## Application for a non-material amendment following a grant of planning permission. Town and Country Planning Act 1990

SINGLE STOREY EXT TO VILLAGE HALL TO PROVIDE STORAGE, SHEDS REMOVED, RAMP TO ENTRANCE HALL

PF/23/1283

SIZE OF RAMP AMENDED

Scales As shown @ A2	Drawn LA Checked
Drawing No. 040-23-02A	Issue PLANNING

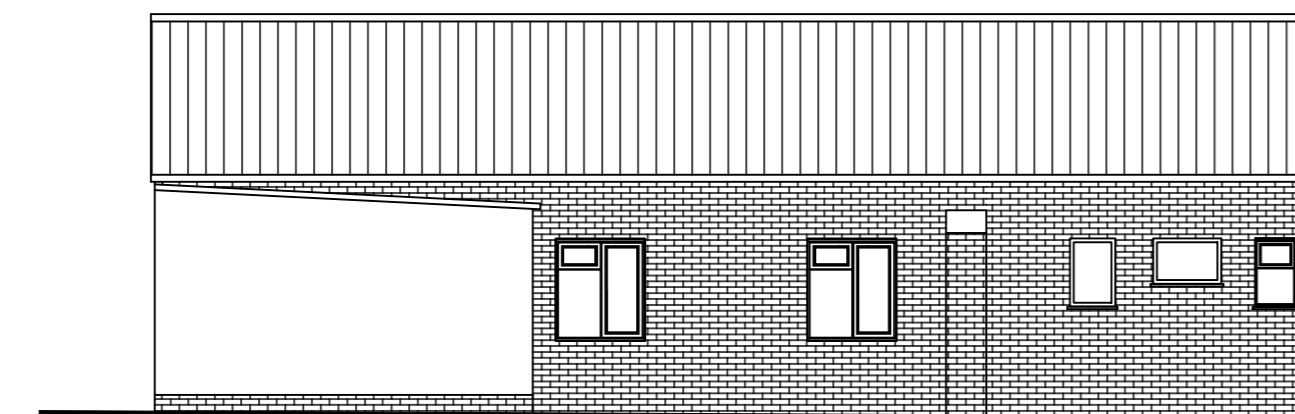
B/REGS REQUIREMENT
